BE/93/07**PLANNING APPLICATION REPORT**

DESCRIPTION/ ADDRESS	- Ground and first floor extension (Re-submission following BE/33/07) 3 Babsham Cottages, Babsham Lane Bognor Regis
-------------------------	--

Ground and first floor extension (Re-submission following BE/33/07/)

3 Babsham Cottages
Babsham Lane
Bognor Regis

NEW SOUTH ELEVATION

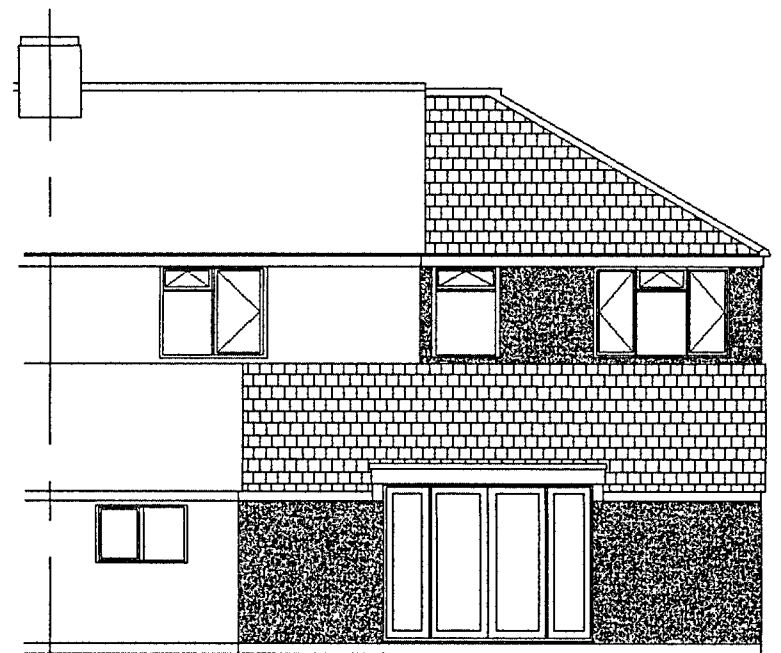
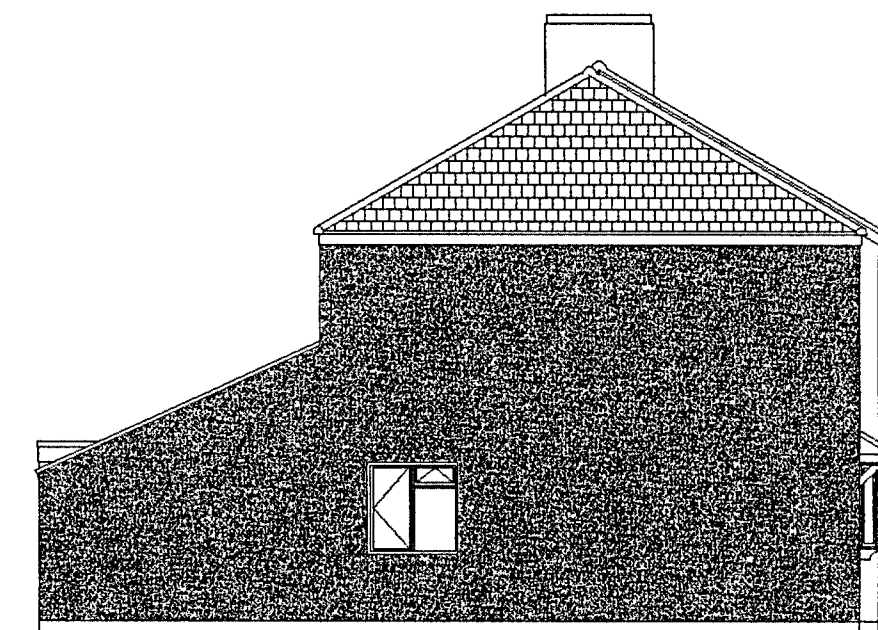
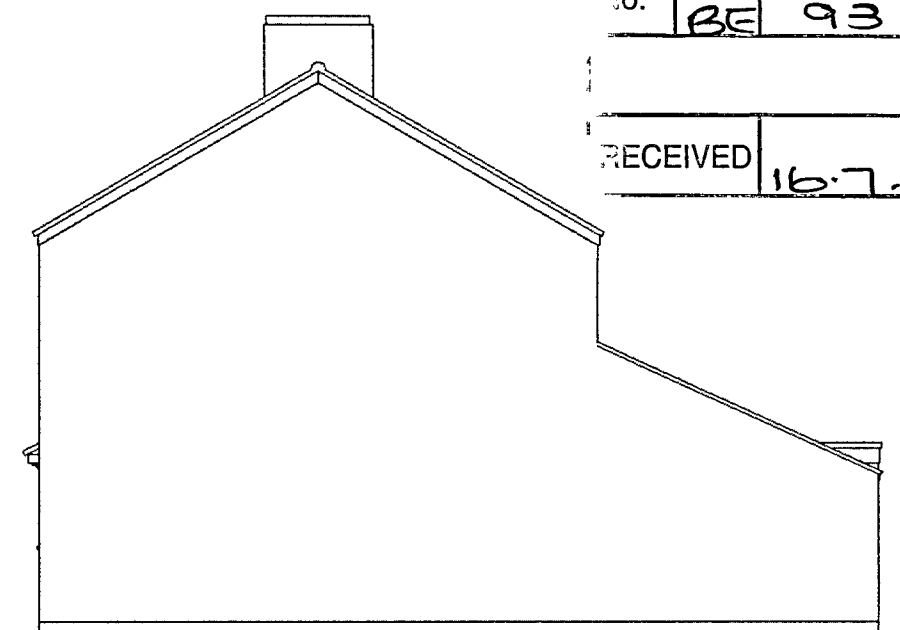
DESCRIPTION OF APPLICATION	The proposal is for the erection of a two storey extension to the west side of the property and a single storey rear extension. The side extension would measure 4.5m in width, 7.1m in depth and 7.2m in height with a hipped end. The rear extension would measure 6.9m in width, 3.5m in depth and 3.6m in height with a monopitched roof. All measurements are approximate.
SITE AREA	0.05 hectares approximately.
RESIDENTIAL DEVELOPMENT DENSITY (NET)	N/A
TOPOGRAPHY	Slightly undulated.
TREES	None of any significance to be affected by the proposed development.
BOUNDARY TREATMENT	2m high hedge to site frontage, rising to 2.5/3m to west side. Fencing to east side and rear of the application site which varies in height (1-2m). All measurements are approximate.
SITE CHARACTERISTICS	Two storey semi-detached property. The dwelling consists of pale yellow painted rough rendered walling and a brown tiled gable roof.

It is considered that there are other material considerations to warrant a decision otherwise than in accordance with the Development Plan and/or legislative background. Although the extension is large it is slightly set back from the front of the existing dwelling and has a hipped roof. It is not considered that the extension will have any significant harm on the residential amenities of neighbours or the visual amenities of the rural area.

The main difference between the previously refused application and the current proposal is that the two storey side extension has been reduced in width by approximately 0.8m and would be set back marginally from the front façade and below the main roof line of the existing dwelling. The roofline has also been altered from a gable to a hipped roof.
